From: Simon Davis
Sent: 12 July 2018 10:04
To: Planning.Responses
Subject: FW: Sack Lane, Lidsey, West Sussex - Planning Application No. AL/60/18/DOC

Subject: Sack Lane, Lidsey, West Sussex - Planning Application No. AL/60/18/DOC

Further to our e-mail correspondence last week, please find attached a copy of our revised drawing no. 18094/100'B', showing the amended underground drainage proposals for the above. I also attach further copies of our drawing no.'s 18094/101 and 102 showing drainage and pavement construction details.

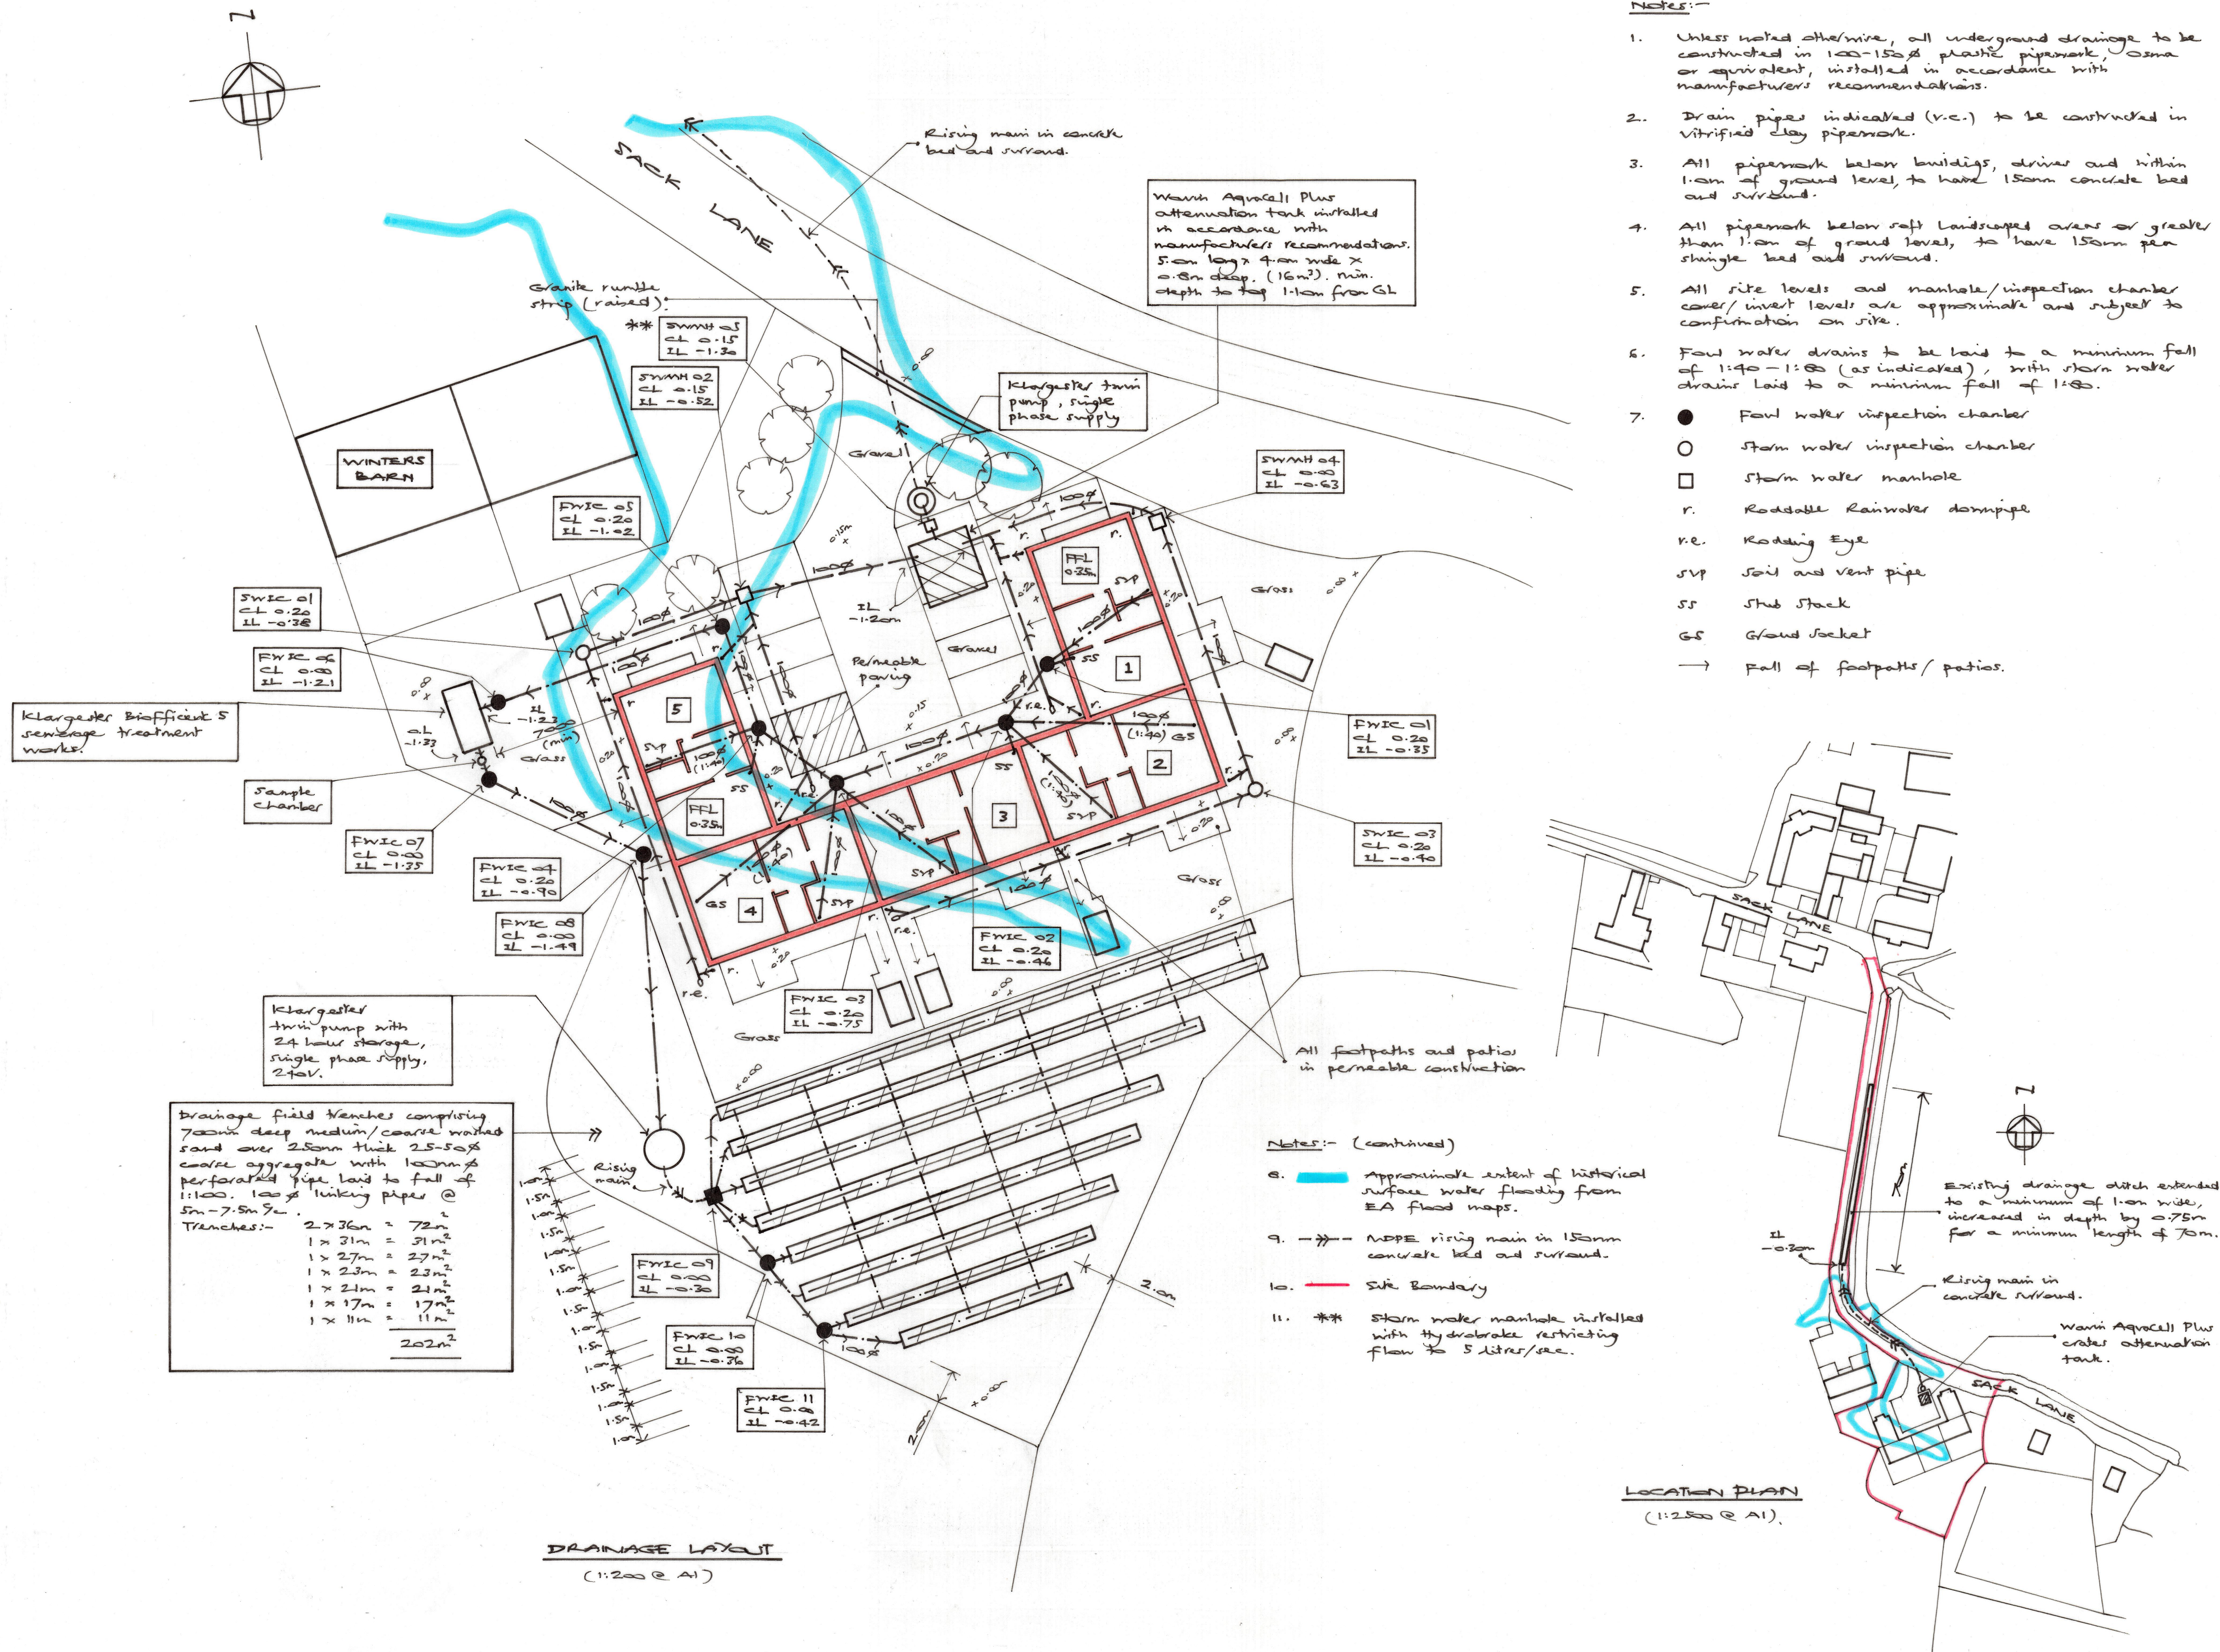
The plans show that you are planning on attenuating surface water on site and then pumping this to discharge to the ditch, which is off site. Please investigate infiltrating surface water on site, i.e. use of a soakaway (set at least 5m away from any building) instead of the attenuation tank. If this is located appropriately it would remove the need for pumping and discharging to the ditch.

I note that the red line site boundary shown on the drainage layout plan is significantly different to that submitted as part of the original planning application. Please correct this on the drainage layout.

- Pumping is not a sustainable solution. This is a last resort measure that I feel there is currently insufficient justification for.
- Why can the surface water not be discharged via infiltration? Foul water final effluent is being infiltrated. Why not the surface water? This would remove the need for the surface water pumping.
- Winter infiltration testing is required to appropriately size the drainage. And winter groundwater monitoring is required to ensure invert levels of infiltration structures are set above the groundwater level.
- There is no detail demonstrating how the discharge of surface water is controlled. I.e. hydrobrake, orifice, pumping rate.

1. Neither ourselves or the applicant want install any pumps. The purpose of incorporating these is simply to raise the discharge levels above any elevated winter groundwater levels, which it will do.
2. Surface water is being discharged via infiltration through the drainage trench.
3. See below.
4. Surface water is controlled through a hydrobrake installed through manhole SWMH 05, limiting flow to 5 l/s, as stated on our drawing no. 18094/100'B'.

If monitoring indicates winter groundwater levels are very high, then we will have no option but to adopt the last resort of pumping, as indicated on our drawing no. 18094/100'B', as this is the only method to raise discharge levels above it. Similarly, if further winter infiltration testing shows the values used in the design submitted are too low, then the size of the drainage trench and drainage field can be increased within the site boundaries.

1. All drainage has been moved onto the 'site' as defined by the red lines shown on the planning drawings.
2. All discharges into the ground have been raised to as high as can practicably be achieved on site using pumps and outside areas indicated at 'medium' risk of flooding from surface water flooding, as shown on the EA's flood maps. In our opinion, this should negate the need for any winter groundwater monitoring, as the drainage cannot physically be lifted any higher on the site.
